I request that the Planning Inspectorate revisit the site and specifically observe the proposed route of HGV traffic down Three Nooks Lane crossing both arterial dual carriageways to the Fylde in the process of continuing down the unadopted historic Chicken Lane down to the River Ribble.

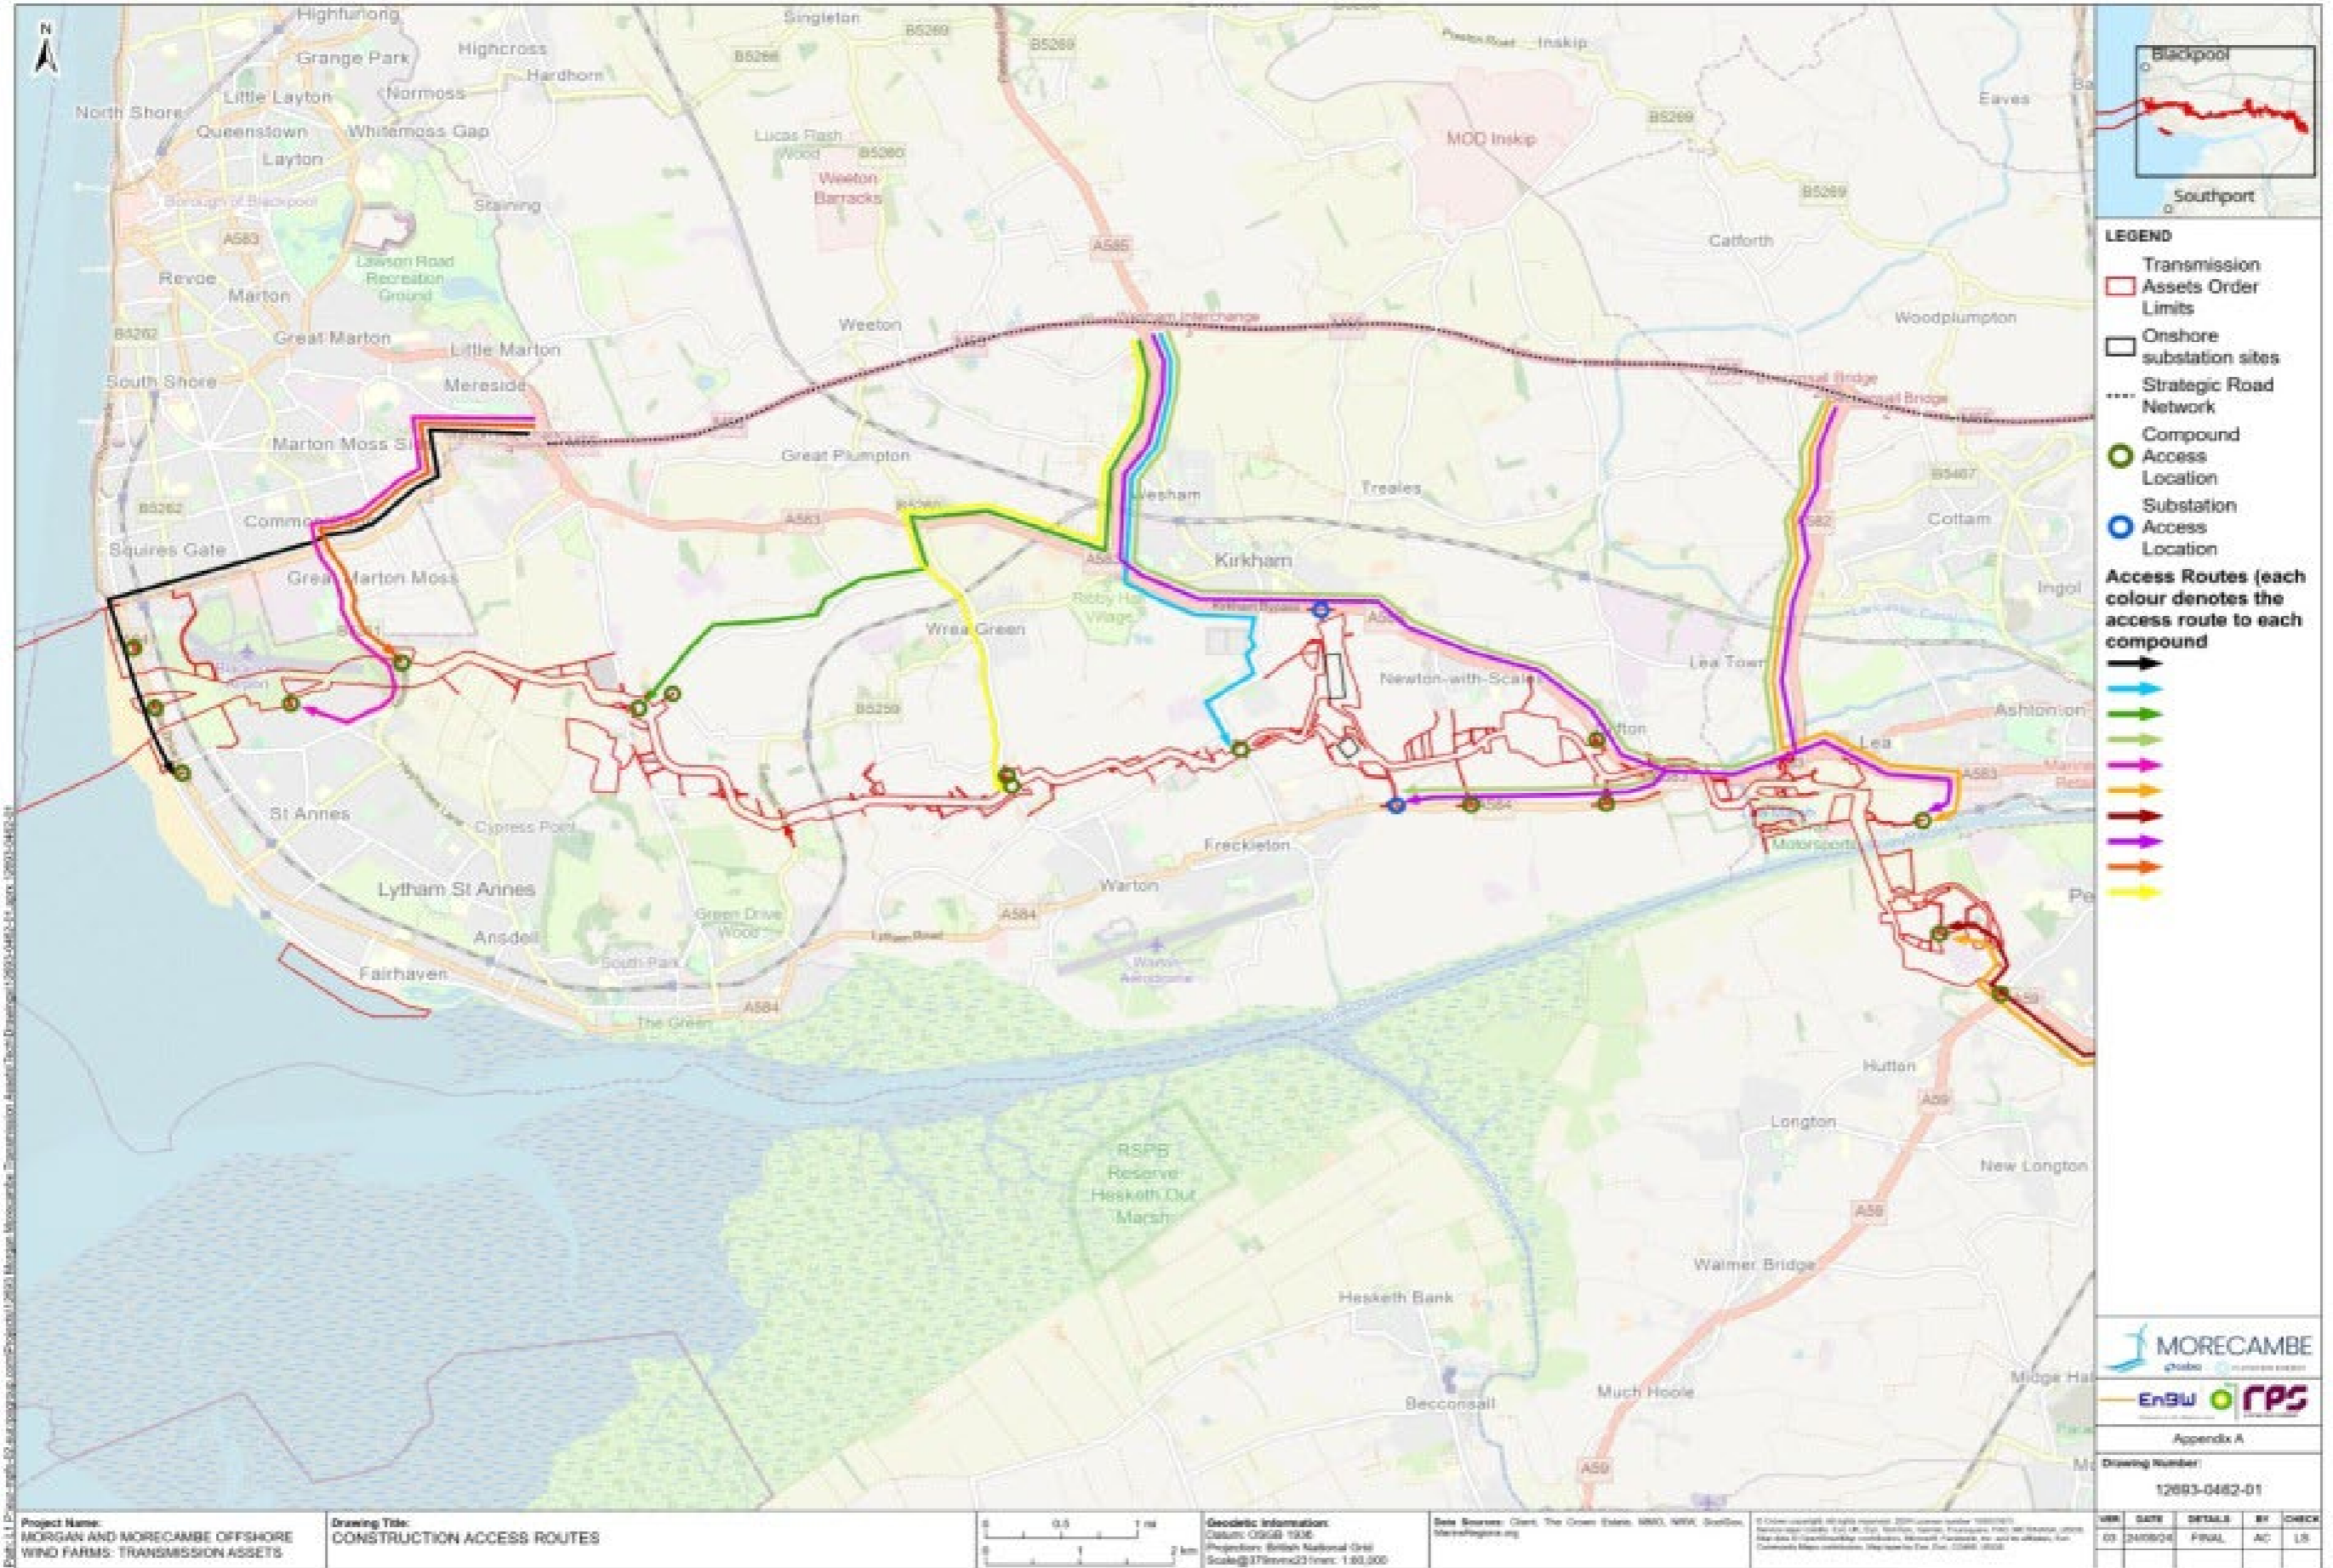
I further request that the Inspectorate request health and safety assessments from Lancashire Constabulary and Lancashire County Council Roads on the viability of using this method of traversing the dual carriageways rather than using the existing traffic lights by "u" turning from Blackpool Road onto Preston Road and thereby avoiding the risk of accidents and an unprecedented log jam.
